Modification to Major Project 06_0210

Rozelle Bay Marine Centre

Lots 29 and 30, James Craig Road, Rozelle

Submitted to
Department of Planning
On Behalf of Rozelle Bay Pty Ltd

Site Plan  
Phase 1 of Stage 1

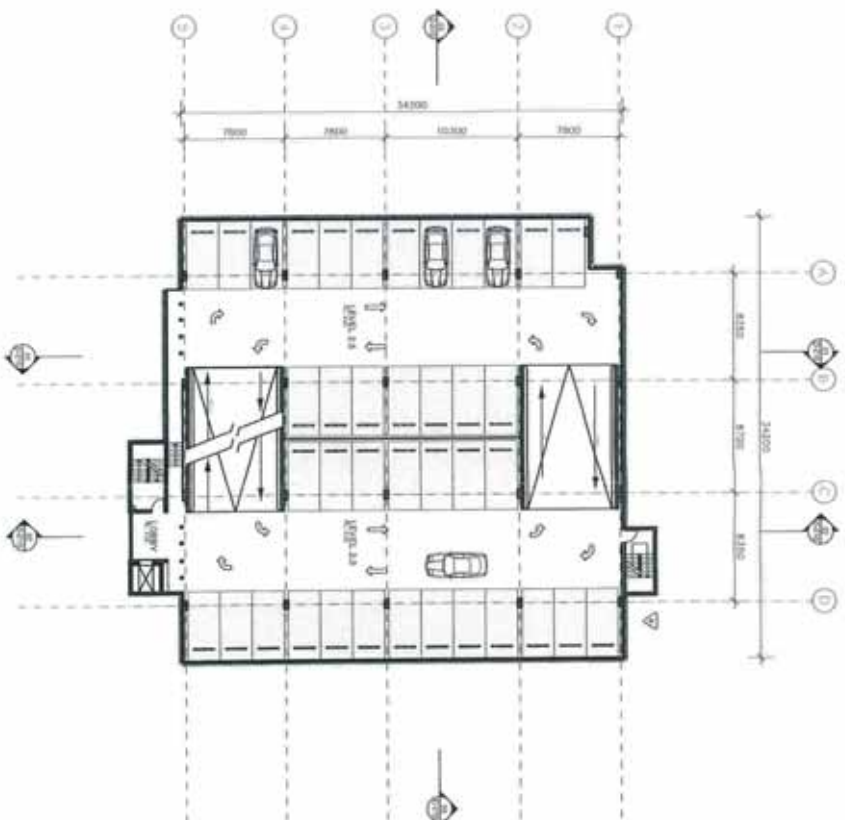
Phase 1 of Stage 1 (refer to **Figure 5**) comprises the construction of the marina berths and on the land a maximum of 100 boats stored at grade on the eastern two thirds of Lot 29 and 50 boats stored on the majority of Lot 30.

Parking for 72 cars would also be provided in the north west corner of Lot 29 while temporary offices and a zone that will either be car or boat storage occupy the south western corner. The far western section of Lot 29 and the southern section of Lot 30 would remain under their current usage.

MP-001-DA	Site Plan Final Development	Issue F Jan 2007
MP-011-DA	Site Plan Phase 1 of Stage 1	Issue N October 2009
MP-012-DA	Site Plan Phase 2 of Stage 1	Issue N October 2009
MP-001-DA	Site Plan Stage 2 Final Development	Issue N October 2009

- E2** *Temporary at grade car parking of 71 spaces on Lot 29 as illustrated on Drawing MP-011-DA.*
- E3** *Temporary use of the layover berths for storage of privately owned vessels is allowed until construction of the Western Boat Store is completed. Temporary layover berthing is to be provided on the eastern side of Marina Arm H until construction of Phase 2 of Stage 1 is complete.*

D-100-DA

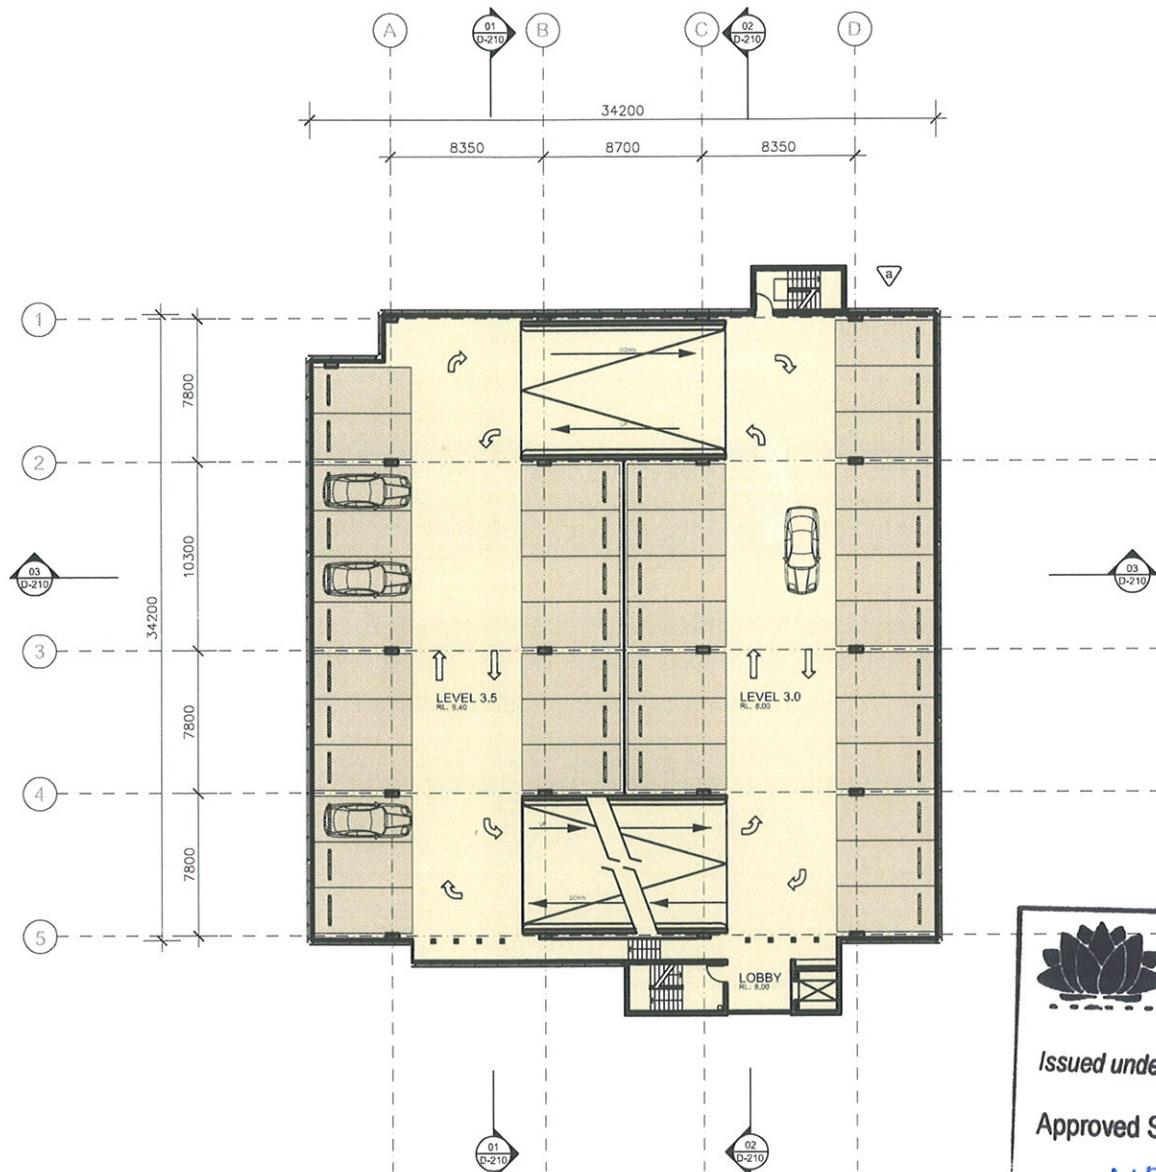
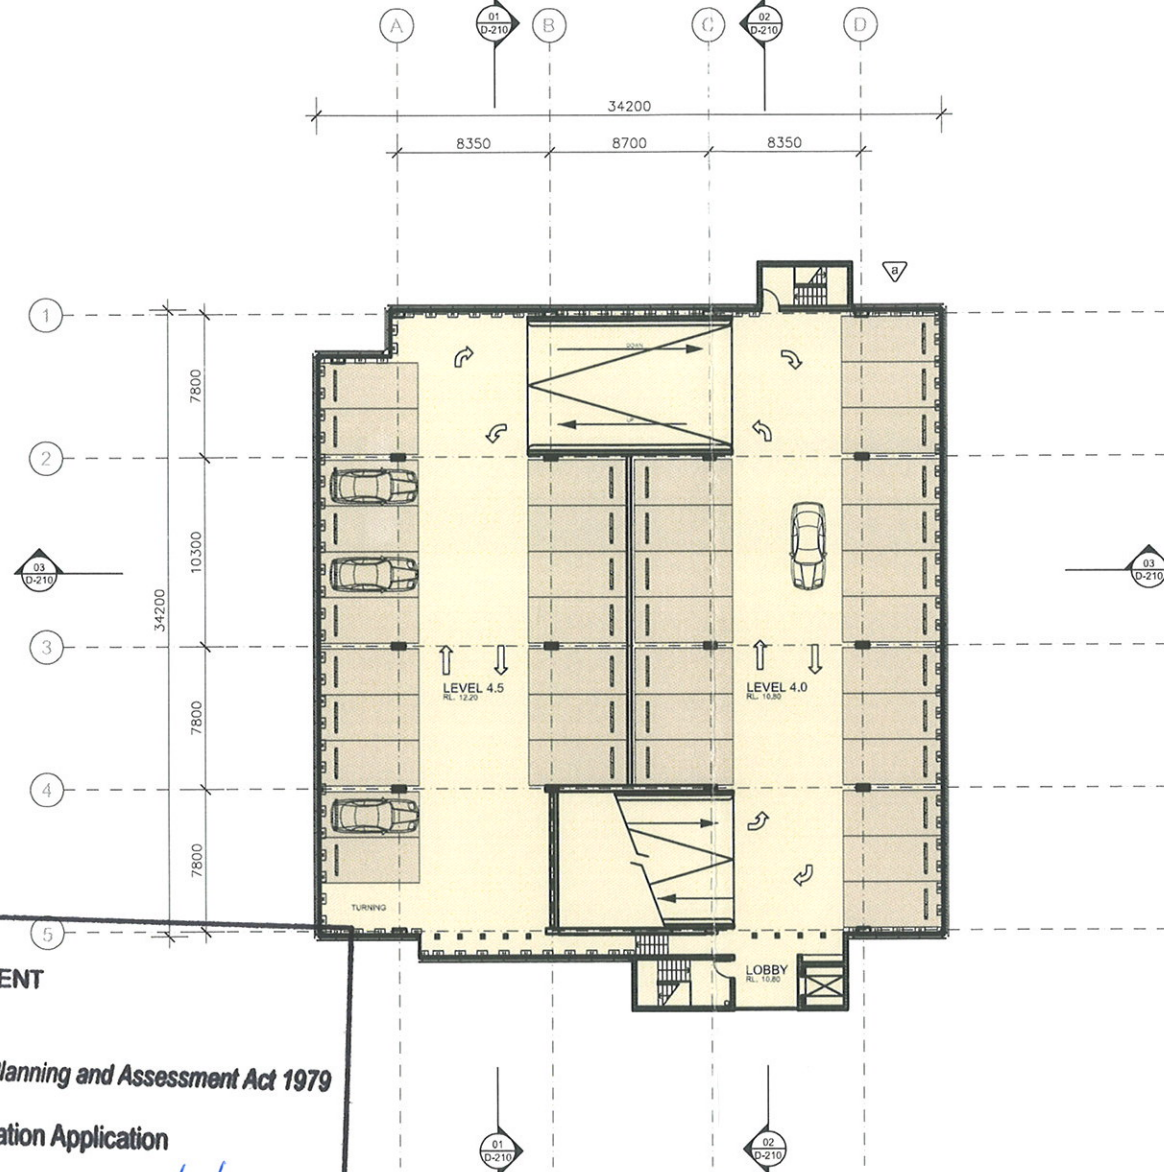
The multi-storey has been redesigned reflecting the conditions imposed in the consent and due to technical construction engineering issues. New plans are proposed to replace the multi-storey car park drawing original approved

Condition A2 (h) of the Major Project Approval requires deletion of Levels 5 and 5.5 of the proposed multi-storey car park. As a result of the condition, Rozelle Bay Pty Ltd have reviewed the design of the proposed car park building. A revised car park building design has been prepared which reduces the bulk and scale of the previously proposed building and satisfies the intent of Condition A2 (h).

Technical construction issues have also arisen during the detailed engineering design of car park. The approved car park was proposed to be constructed over a viaduct. The Sydney Harbour Foreshore Authority (the consent authority at the time of the original approval) did not permit the filling of the viaduct, therefore capping of the viaduct is required. The currently approved design is illustrated in **Figure 1**, with the northern end of the viaduct visible. The design provided a 15.3m gap between the Western Boat Store and the car park building.

The viaduct was found to be too wide to practically and economically span without central supports. Providing piles in the centre proved to be impractical because the ground adjacent the sea wall could not support heavy piling vehicles. It is also not possible to use a piling barge due to the existing wharf and bridge structures.

Therefore the multistorey car park has been redesigned with regard to the conditions of consent which sought to reduce its bulk and scale, and satisfying the technical issues relating to the viaduct.

The site coverage of the multi-storey car park is 1,235m², a reduction of 474 m² compared to the approved car park which has a site coverage of 1709m². The redesigned car park has a maximum roof height of RL 15.9 and the top of the facade is RL 14.4, in accordance with Condition A2(h).

The redesigned car park is generally located in the same area of the site, with the building height and footprint reduced and moved slightly to the west. This has a positive effect as it widens the gap between the car park and the western store opening a view corridor and preventing a wall of development. As illustrated in **Figure 2**, the gap between the multi-storey car park and the Western Boat Store is now 36.3m, double the width originally proposed. Only a limited amount of at grade car parking will be provided over the viaduct.

<i>D-100-DA</i>	<i>Multi-Storey Car Park – Floor Plans</i>	<i>Issue H July 2009</i>
<i>D-101</i>	<i>Multi-Storey Car Park – Floor Plans</i>	<i>Issue H July 2009</i>
<i>D-200-DA</i>	<i>Multi-Storey Car Park – Elevations</i>	<i>Issue H July 2009</i>
<i>D-210-DA</i>	<i>Multi-Storey Car Park – Sections</i>	<i>Issue H July 2009</i>

Multi Storey Car Park
Floor Plans

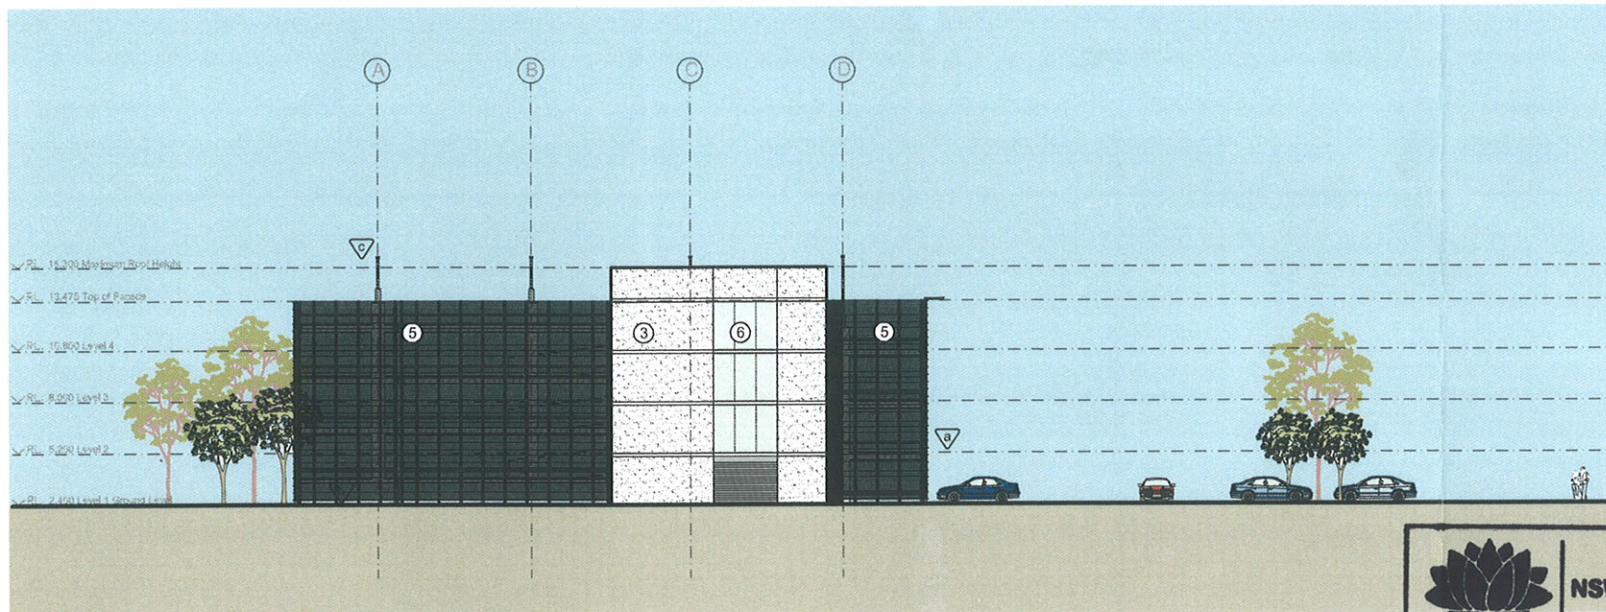
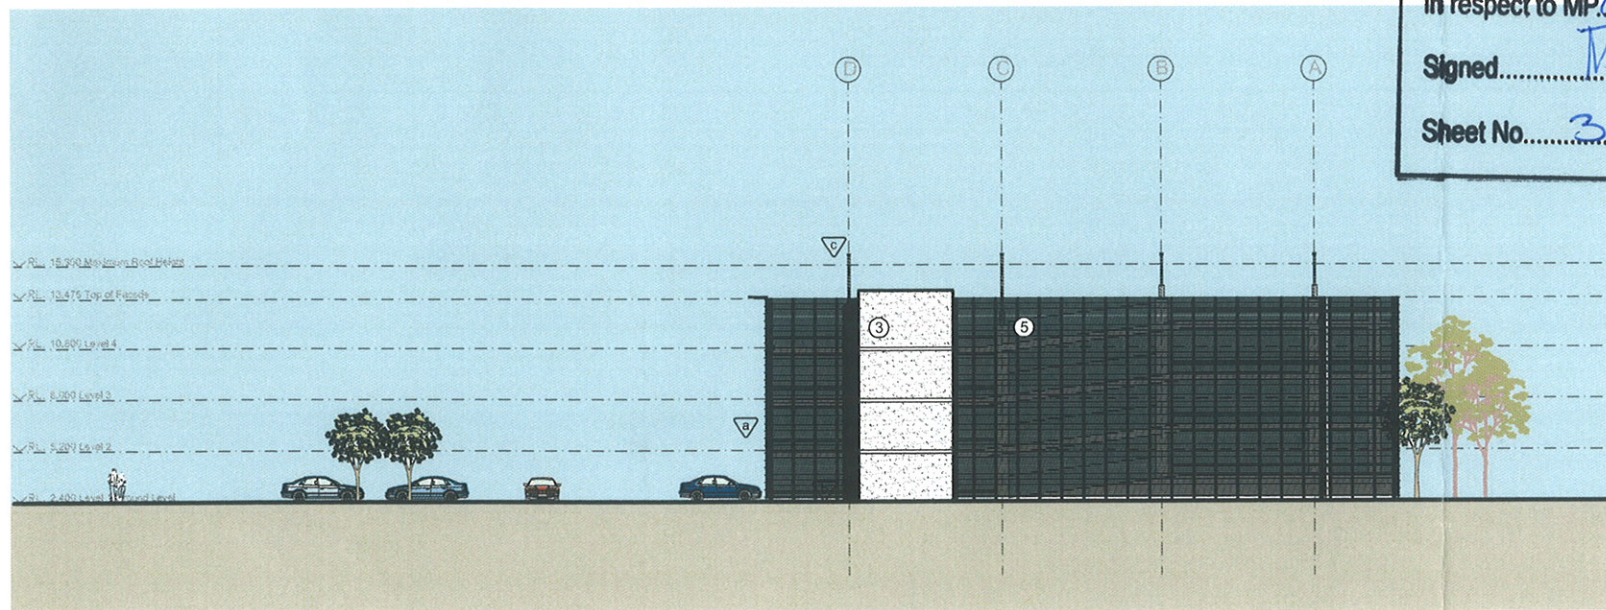
The carpark redesign does however push the northwest corner into the designated setback. It is considered that this will not have a material effect on the streetscape as the setback encroachment is limited to the northwest corner and landscaping and a footpath can still be provided. The proposal meets the required setback to the east and south. **Figure 3** illustrates the extent of change between the approved design (green dashed line) and the proposal.

Site Plan
Phase 2 of Stage 1

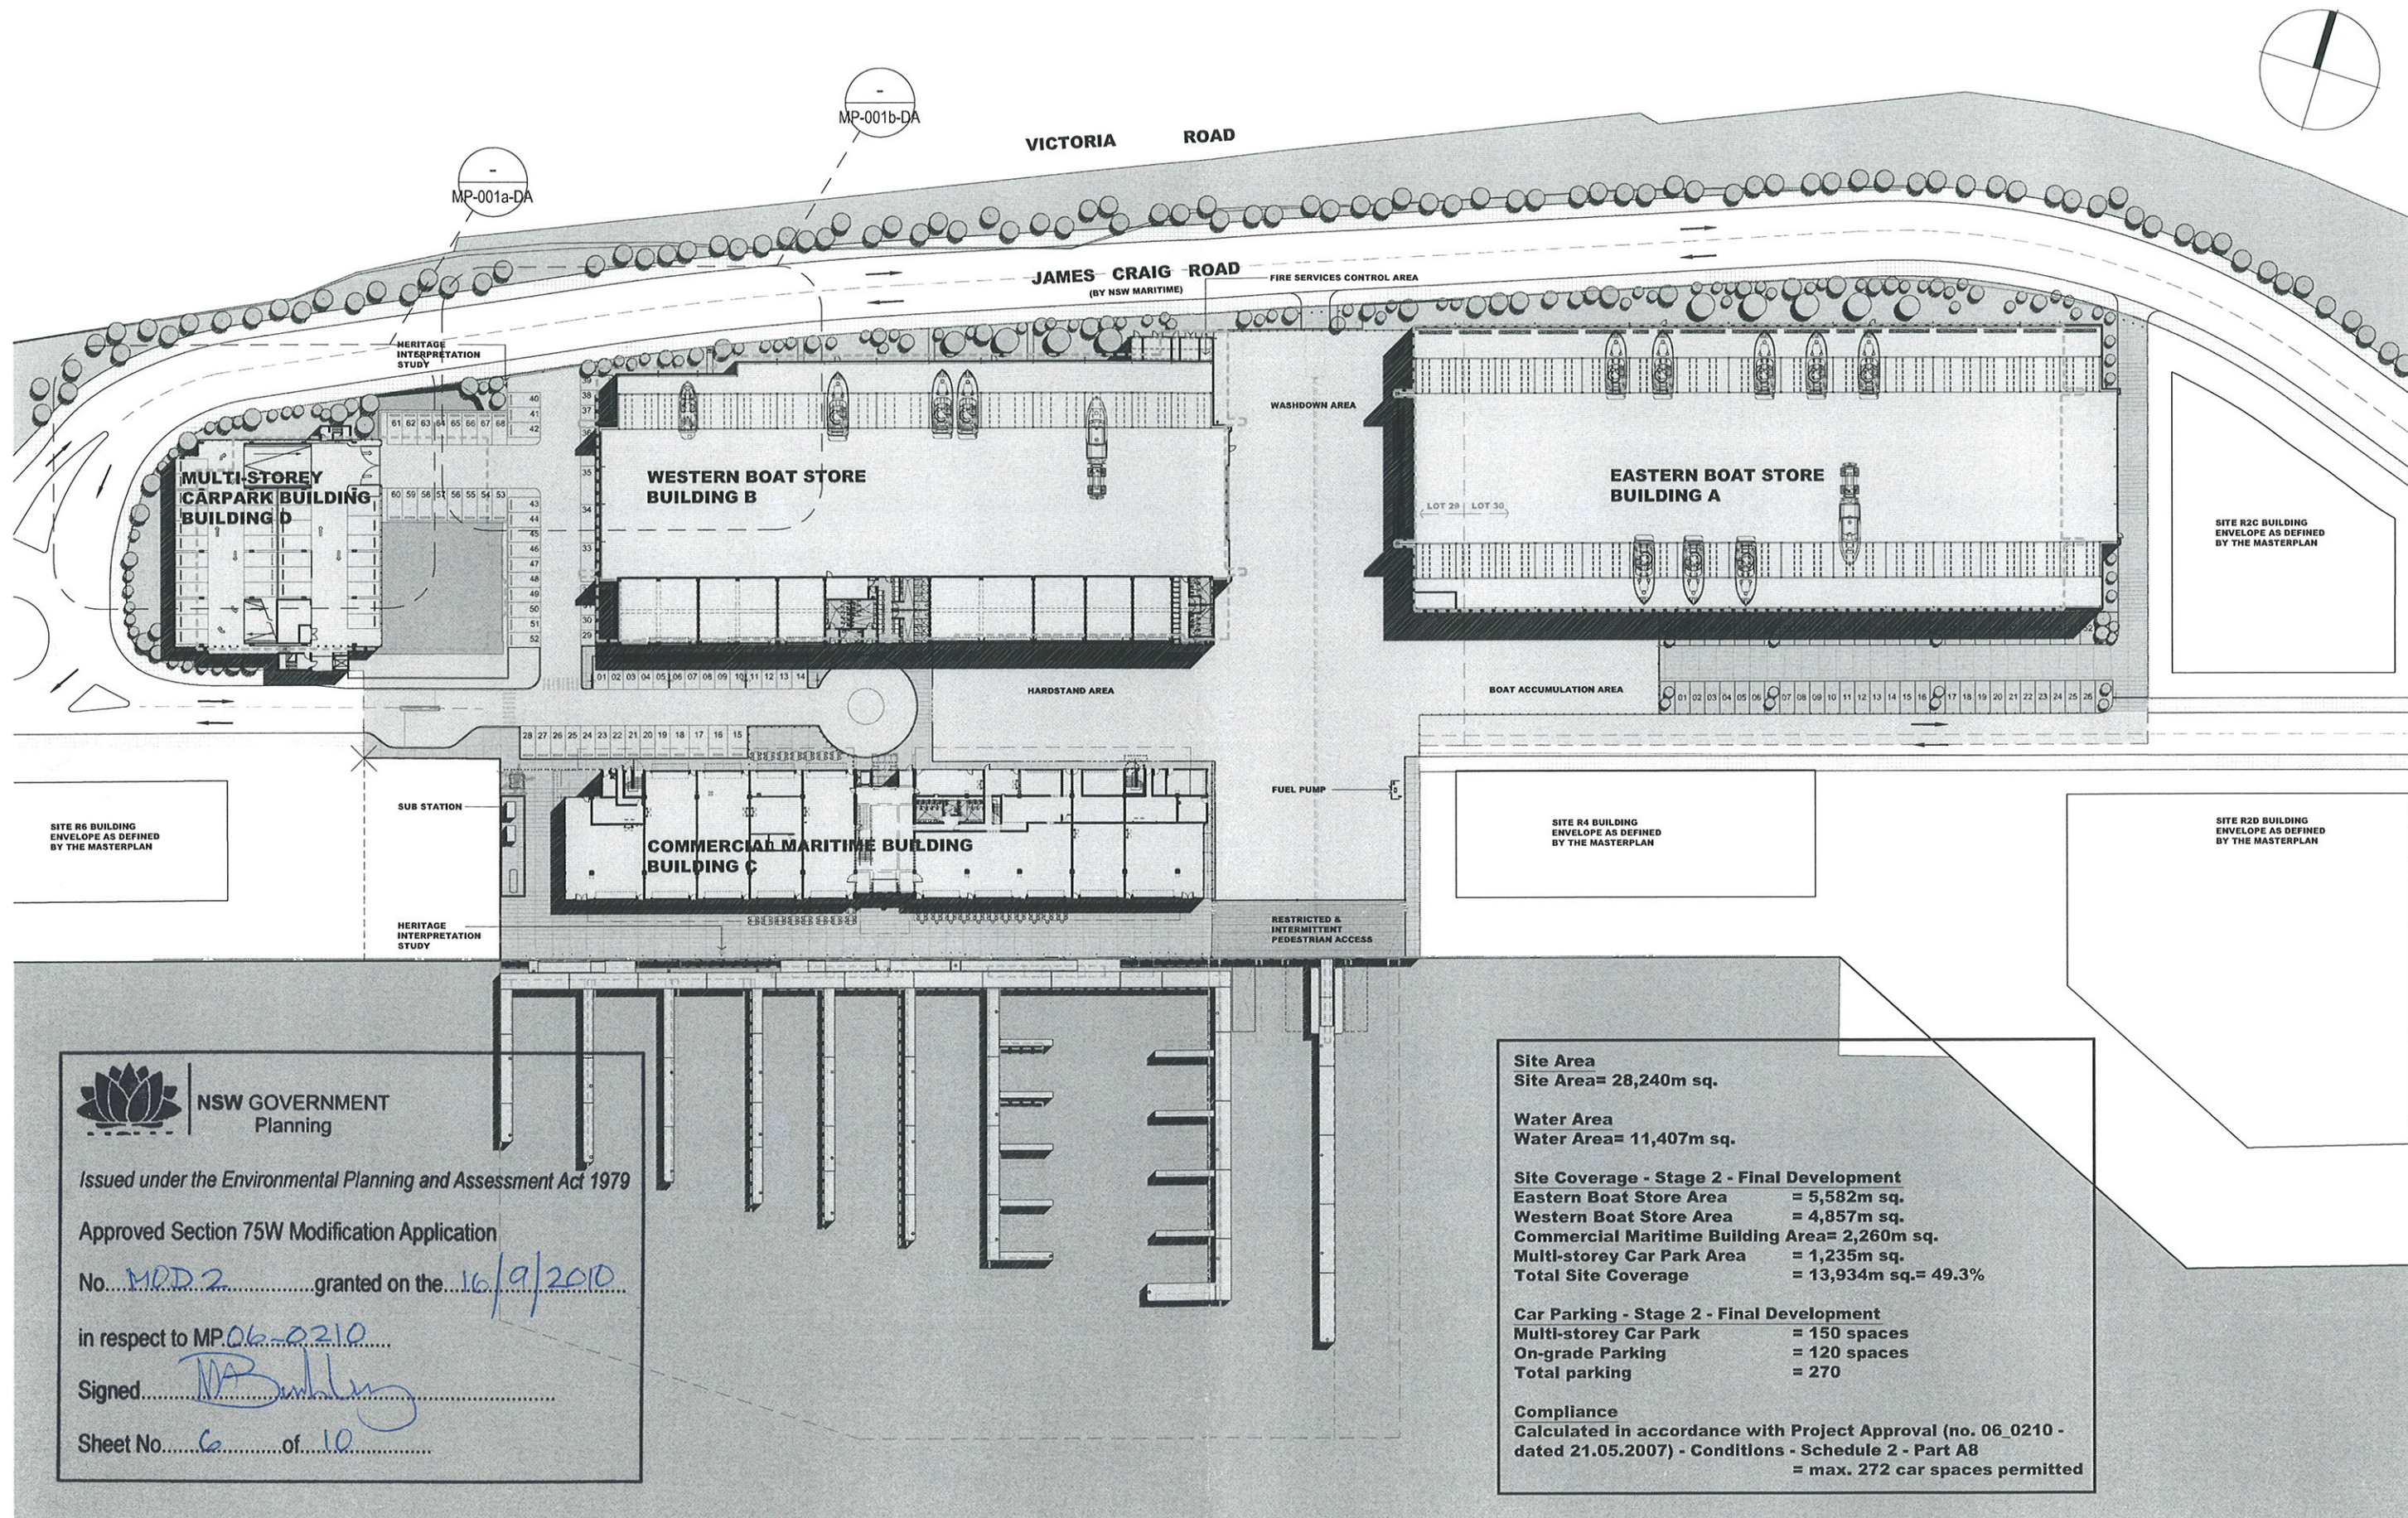
Phase 2 of Stage 1 (refer to **Figure 6**) comprises the construction of the Commercial Maritime Building and Western Boat Store. To facilitate this construction the boats stored on Lot 29 will be relocated onto Lot 30. The far western at grade car park on Lot 29 will be constructed and 50 of the car parking spaces in the temporary Lot 29 car park will be transferred to it. The remainder of

the car parking spaces will be in the unused south section of Lot 30. The temporary offices will remain in place.

Following construction of the concrete hardstand over the eastern portion of Lot 29, the car parking spaces stored on Lot 30 will be moved to a new temporary car parking area on the hardstand on Lot 29, east of the Western Boat Store. Additional car parking will be provided to the west of the Western Boat Store and in the area between the Western Boat Store and the Commercial Maritime Building.
